**ANGEL PLACE  
LEVEL 8, 123 PITT STREET  
SYDNEY NSW 2000**

15 December 2023

## **DESIGN INTEGRITY PANEL ENDORSEMENT - ALEXANDRIA HEALTH CENTRE**

This letter has been prepared on behalf of the Design Integrity Panel (**DIP**) for the Alexandria Health Centre State Significant Development (**SSD**), in relation to the design integrity process. It provides endorsement of the design by the Design Integrity Panel (DIP) prior to the lodgement of the SSDA.

Drawing No DA-A30.001
Revision

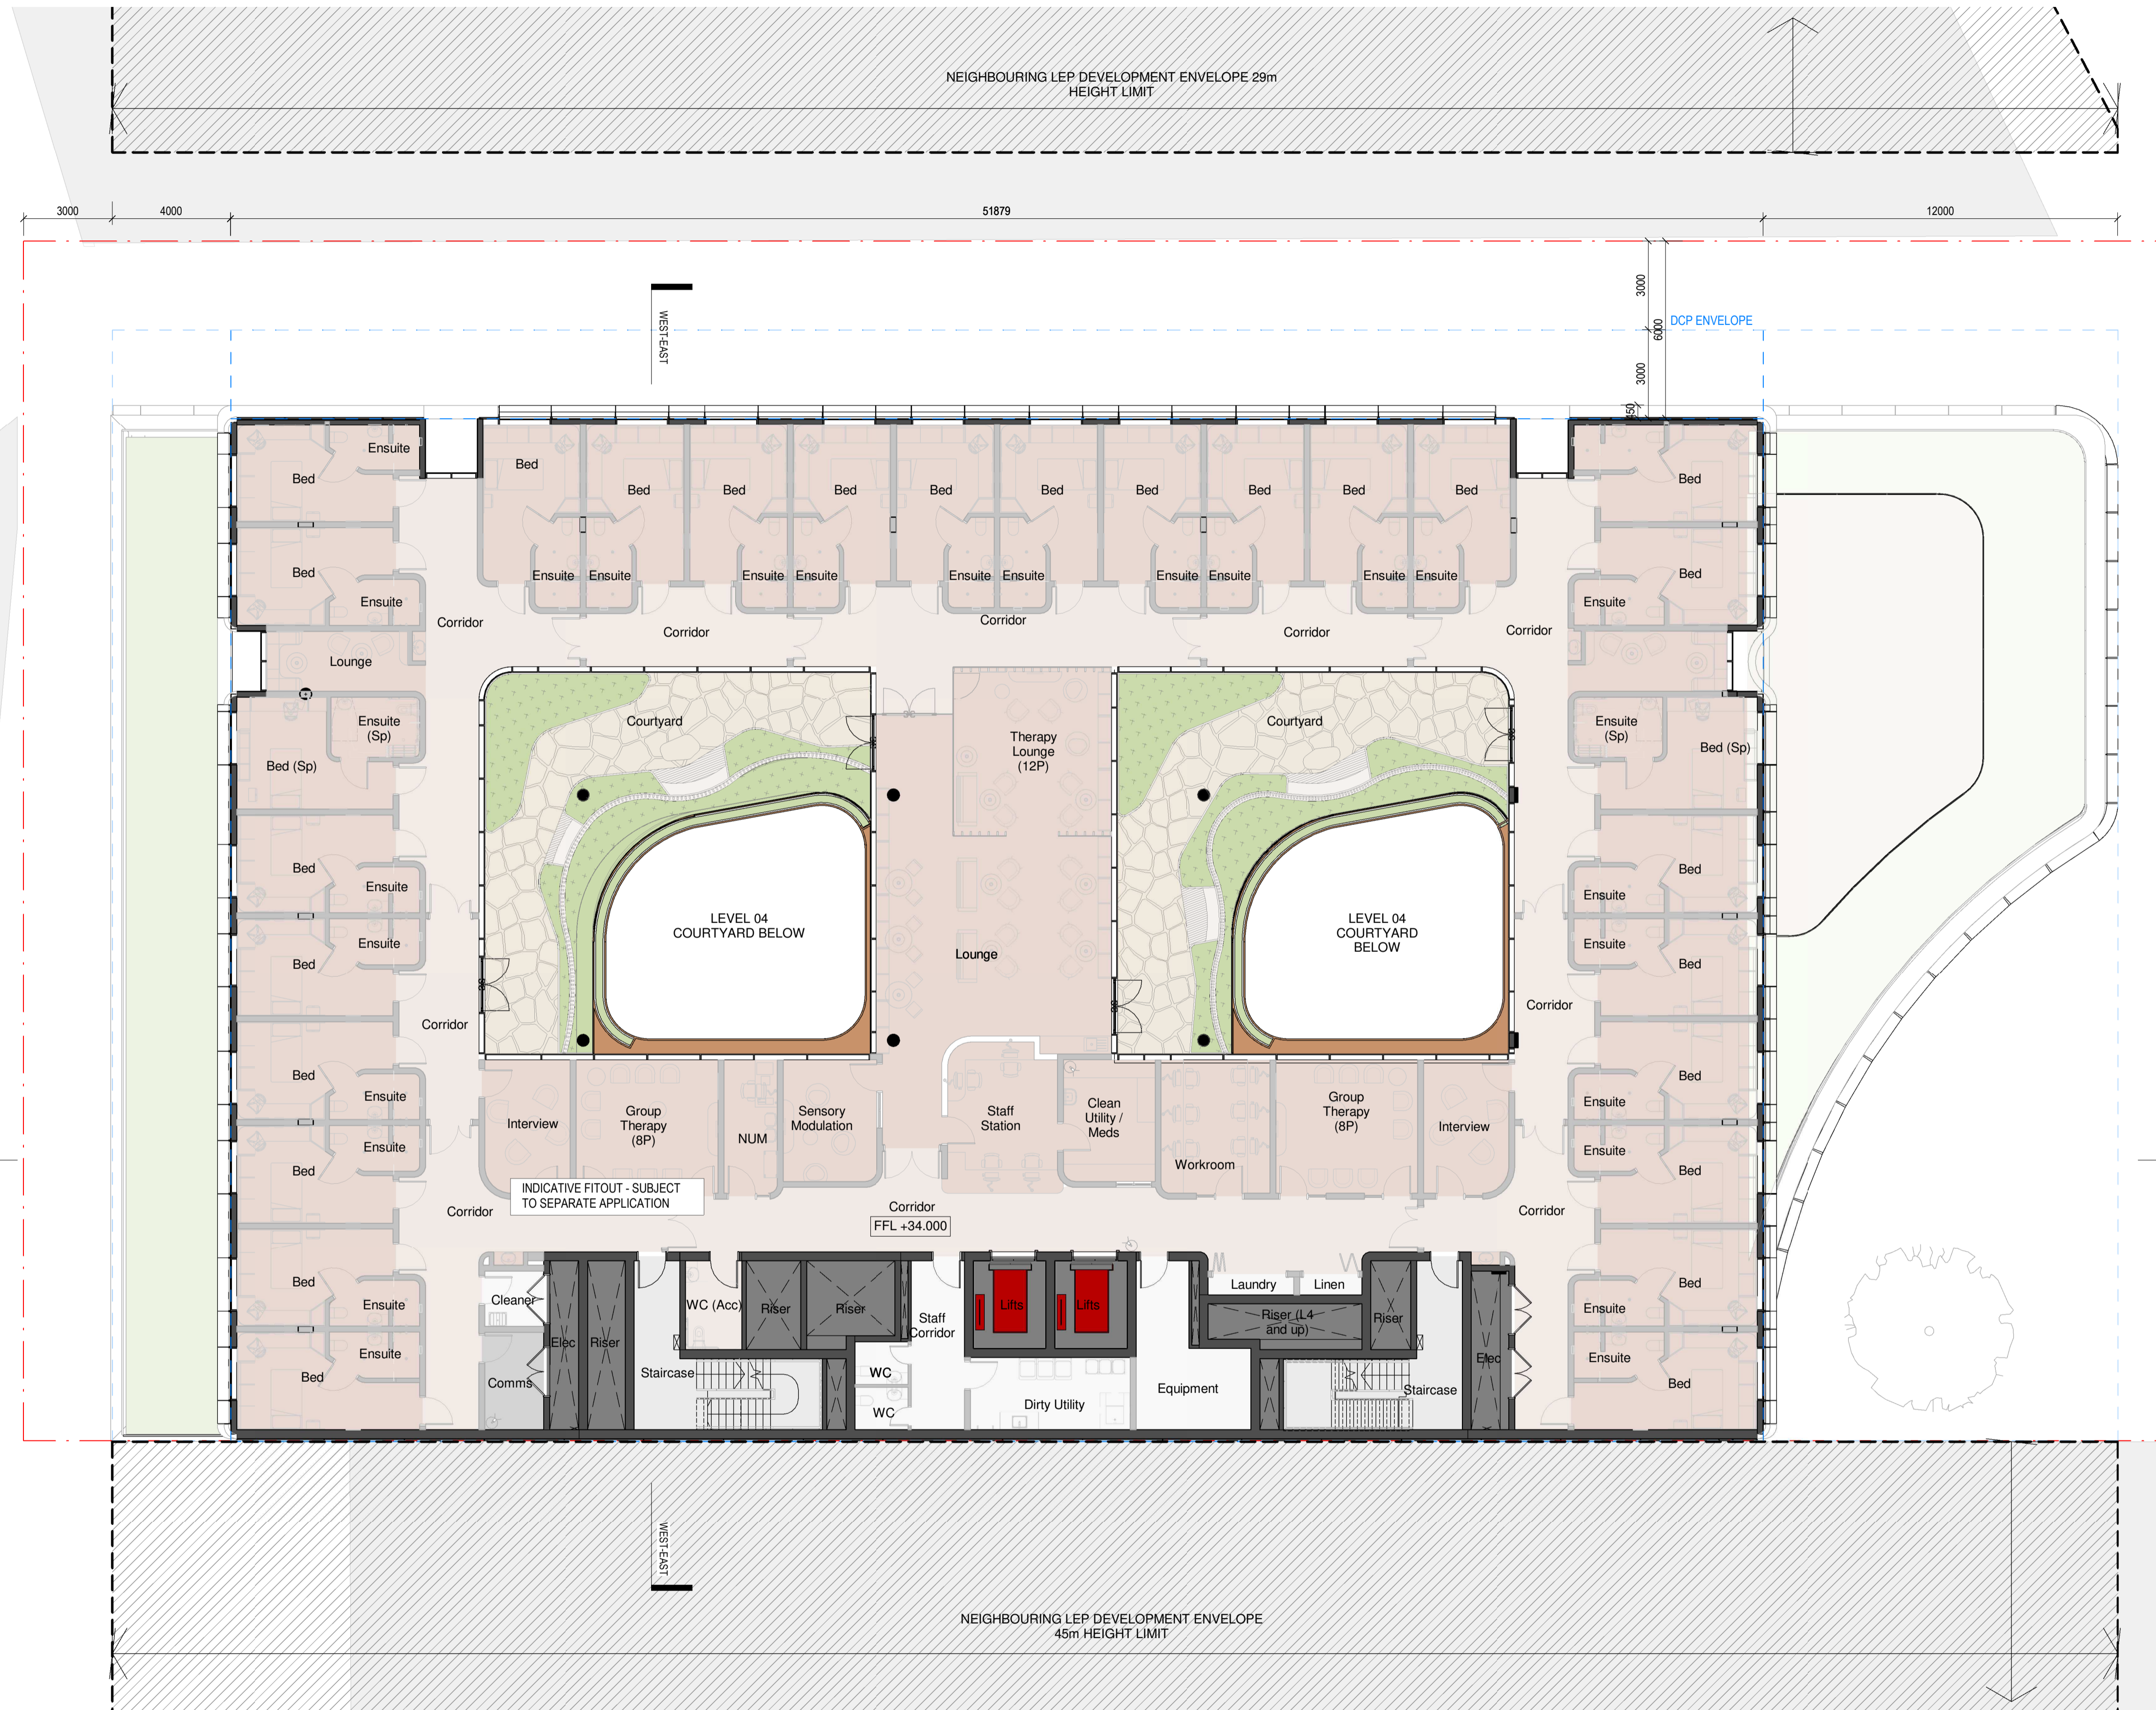
Focus Areas	Panel Commentary
	<p>1.17 The Panel noted the planters on the façade were not fundamental to design excellence and their removal would be supported provided that the level 4 podium rooftop planting is enhanced.</p> <p>1.18 The Panel do not oppose the use of aluminium instead of terracotta, provided that a similar ‘matte like’ finish and layered façade look is still achieved.</p> <p>1.19 The Panel highlighted the flat fascia elements as a key element to retain as part of any revised façade design, to retain the breaks in composition, distortion in the overall regularity and light reflection of the competition scheme.</p> <p>1.20 The Panel offered the Project Team another meeting to discuss the design refinements and feedback if required.</p>

Focus Area	Panel Commentary
<p><b>Revised façade design</b></p>	<p>2.1 The Panel noted that the revised design has not lost design quality from the competition scheme. The reduction in complexity and number of elements on the façade has generally improved the scheme.</p> <p>2.2 The Panel are supportive of the removal of the façade planter boxes, subject to meaningful landscaping on the podium rooftop, which will provide amenity to street and patients</p>

Drawing Title
EAST ELEVATION

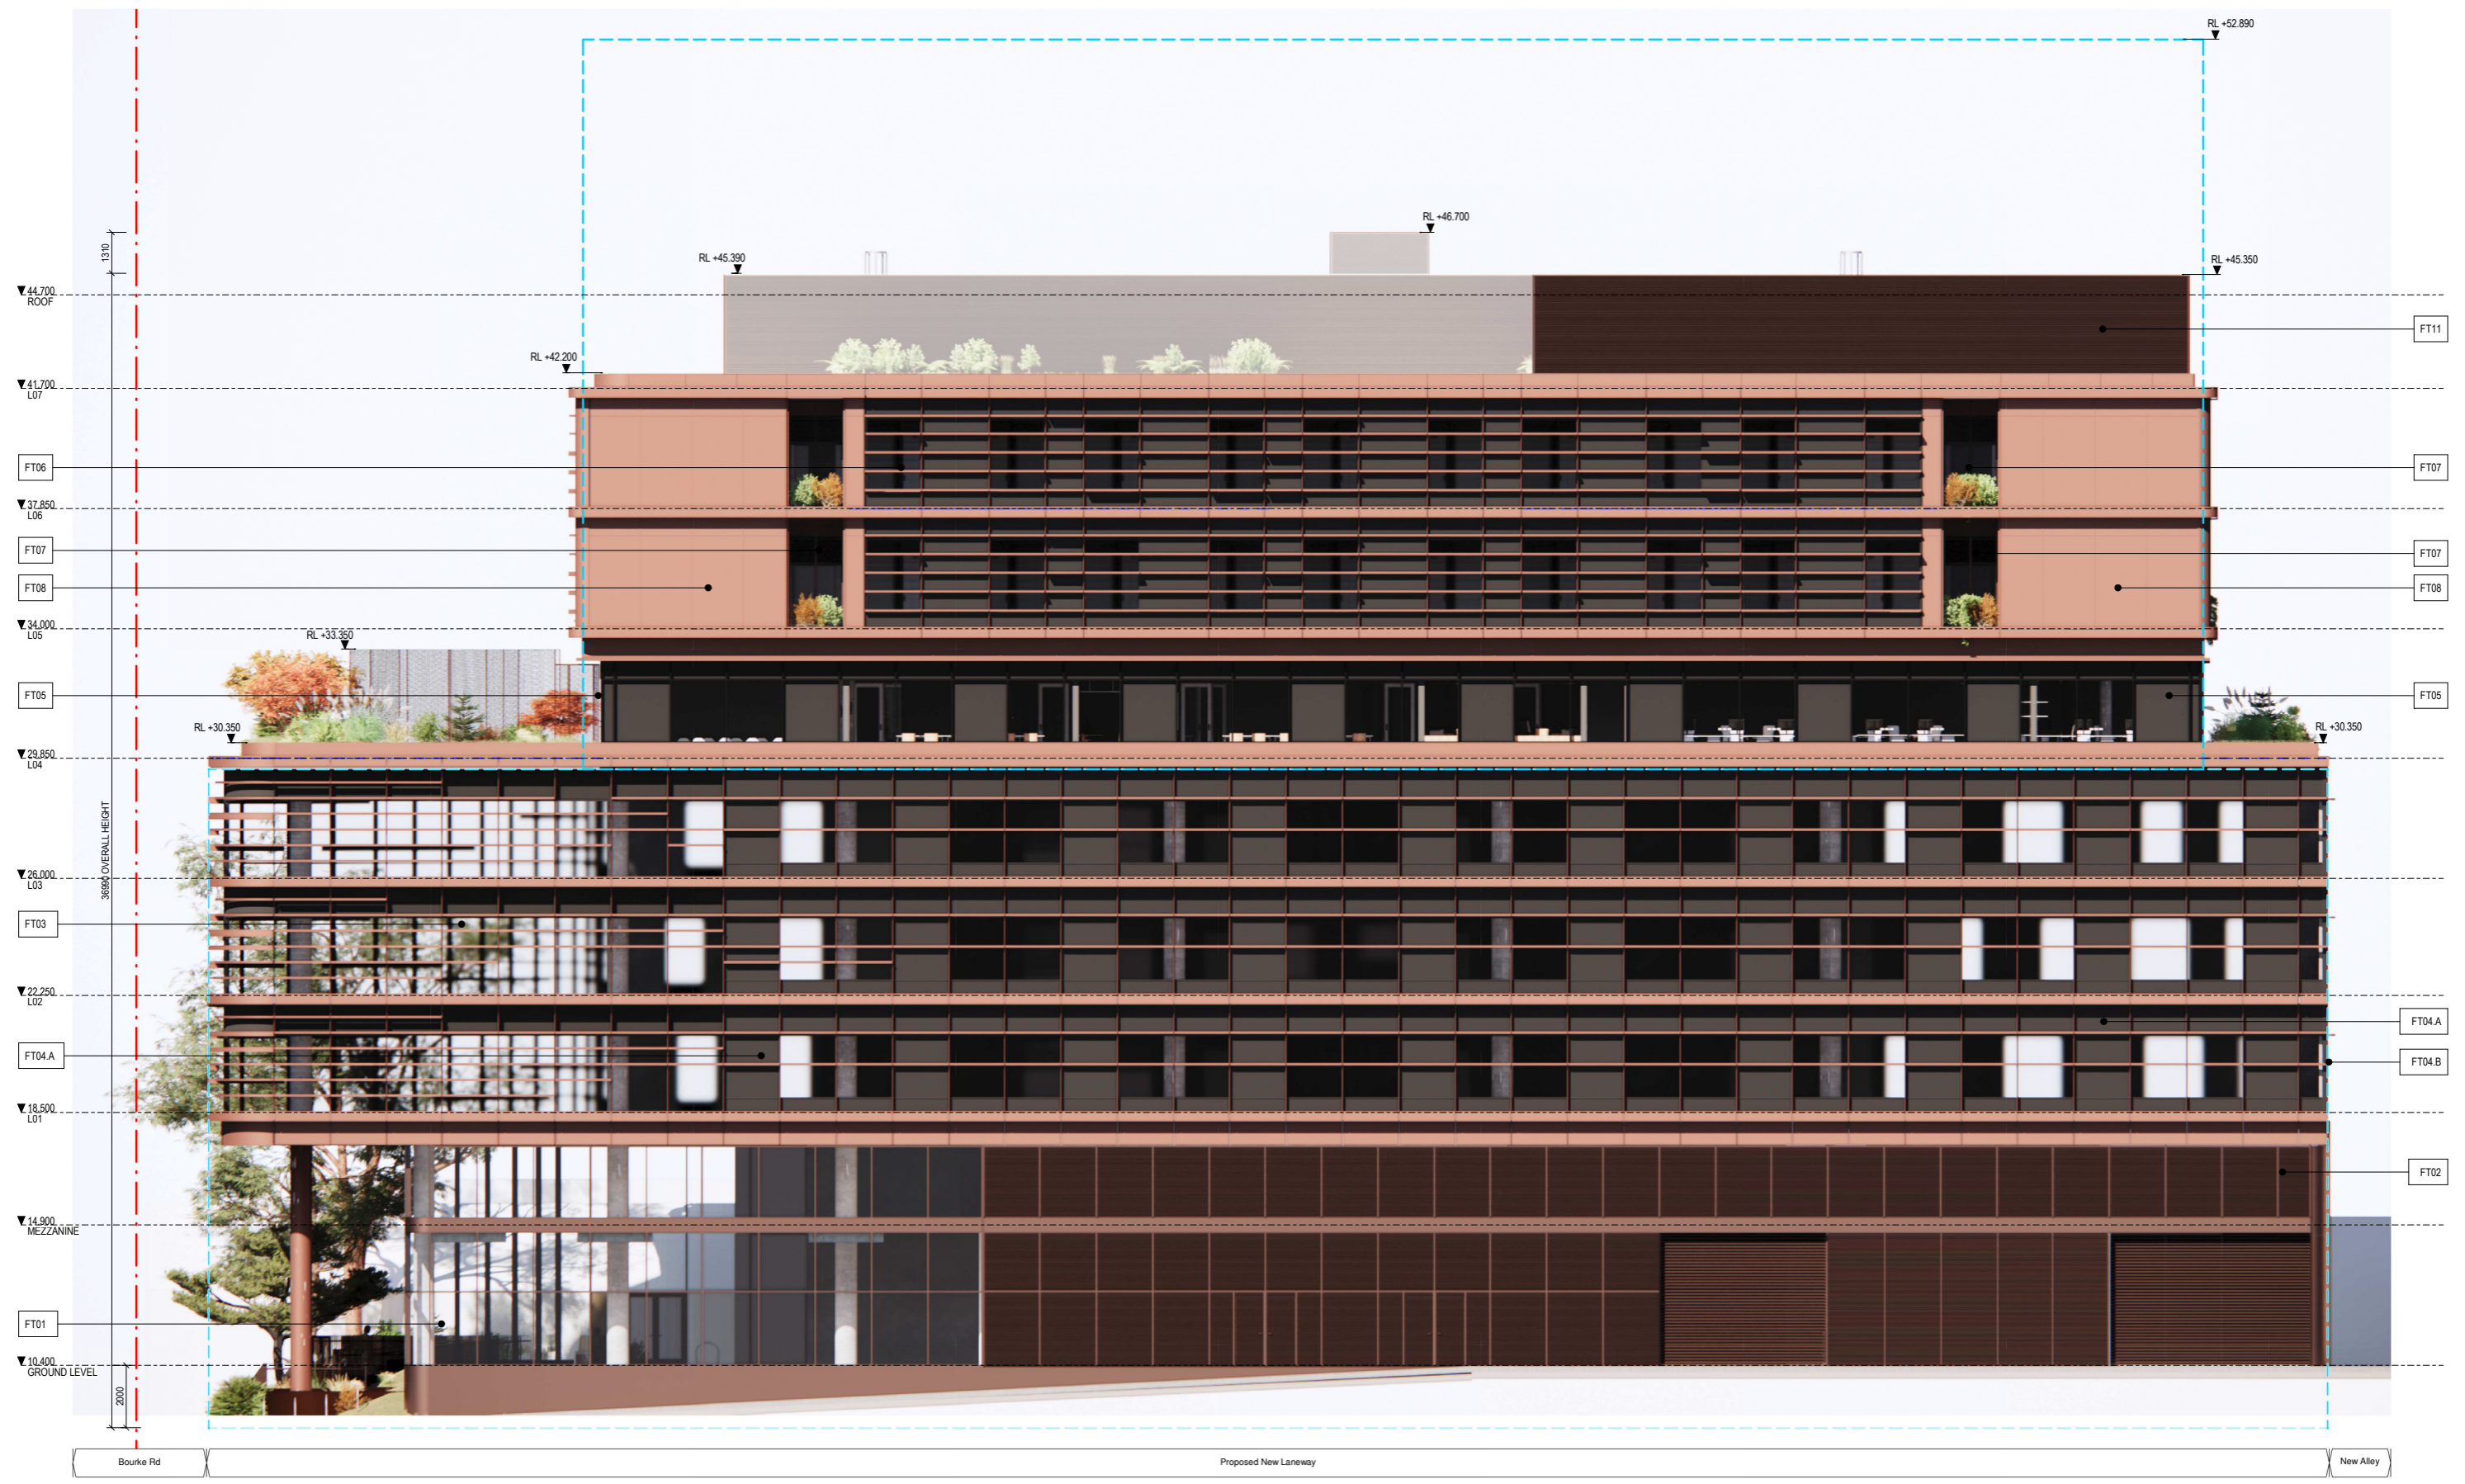
<b>Floor plates and natural light</b>	1.7 The Panel supported the improvements to natural light through additional openings to the eastern façade, and noted that this should be included within the final design.
